From: Lewis, Trevor <Trevor.Lewis@lancashire.gov.uk>
Sent: 04 June 2014 09:41
To: Stephen Kilmartin
Cc: planning; ENV LHS Customer Service
Subject: 3/2014/0331 Whiteacre Lane Barrow

My comments on this application are similar to those made on the previous application number 3/2013/0902.

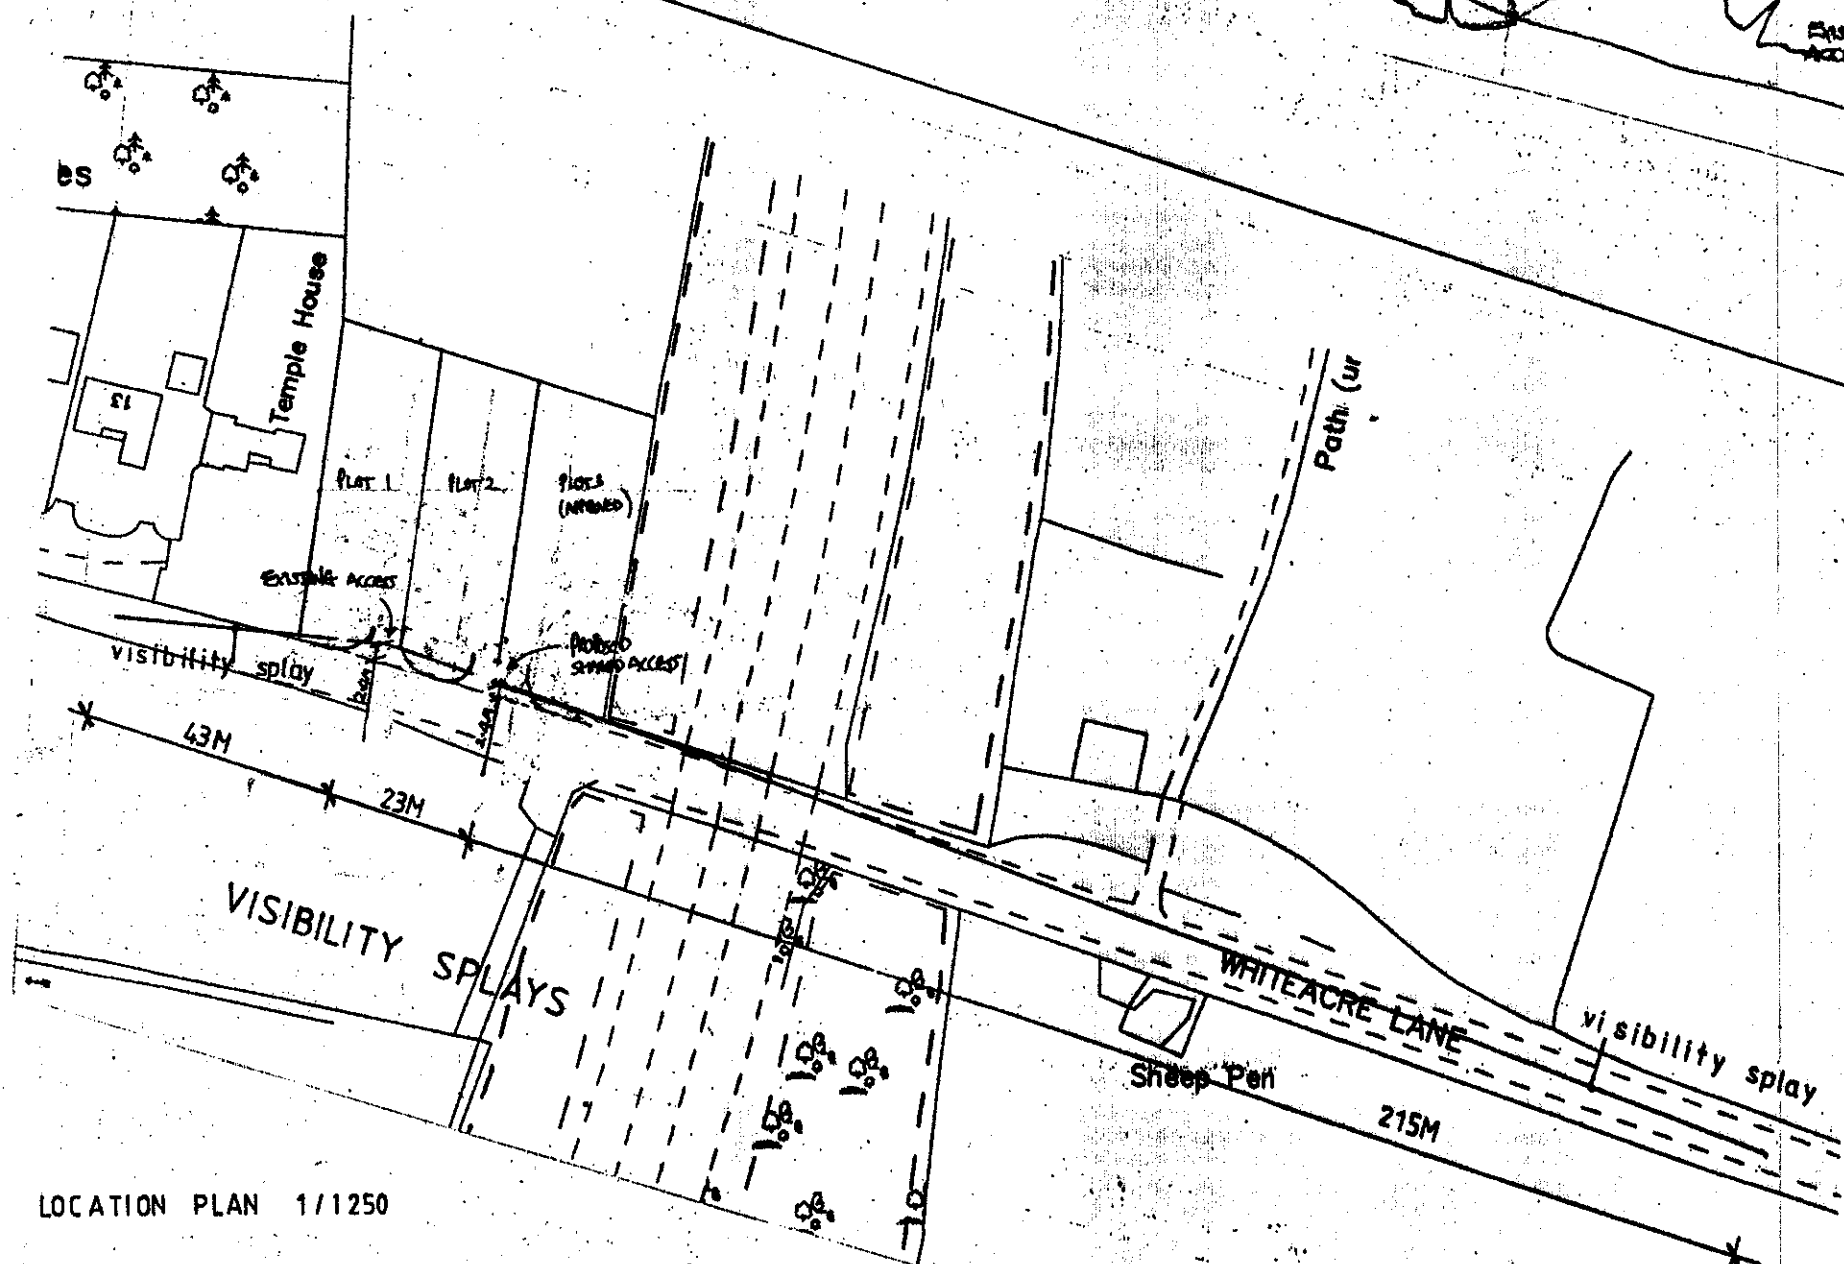
Please ask the developer to provide visibility splays of 2.4m by 43m in each direction at each access to the two dwellings. The access to each property from Whiteacre Lane should be formed using drop kerbing.

In addition storm water from the properties should not be allowed to discharge on to the highway.

Notwithstanding the provisions of the Town and Country Planning (General Permitted Development) Order 1995 there shall not at any time in connection with the development hereby permitted be erected or planted or allowed to remain upon the land hereinafter defined any building, wall, fence, hedge, tree, shrub or other device.

The visibility splay to be the subject of this condition shall be that land in front of a line drawn from a point 2.4m measured along the centre line of the proposed access from the continuation of the nearer edge of the carriageway of Whiteacre Lane to points measured 43m in each direction along the nearer edge of the carriageway of Whiteacre Lane, from the centre line of the access, and shall be constructed and maintained at footway/verge level in accordance with a scheme to be agreed by the Local Planning Authority in conjunction with the Highway Authority. Reason: To ensure adequate visibility at the site access.
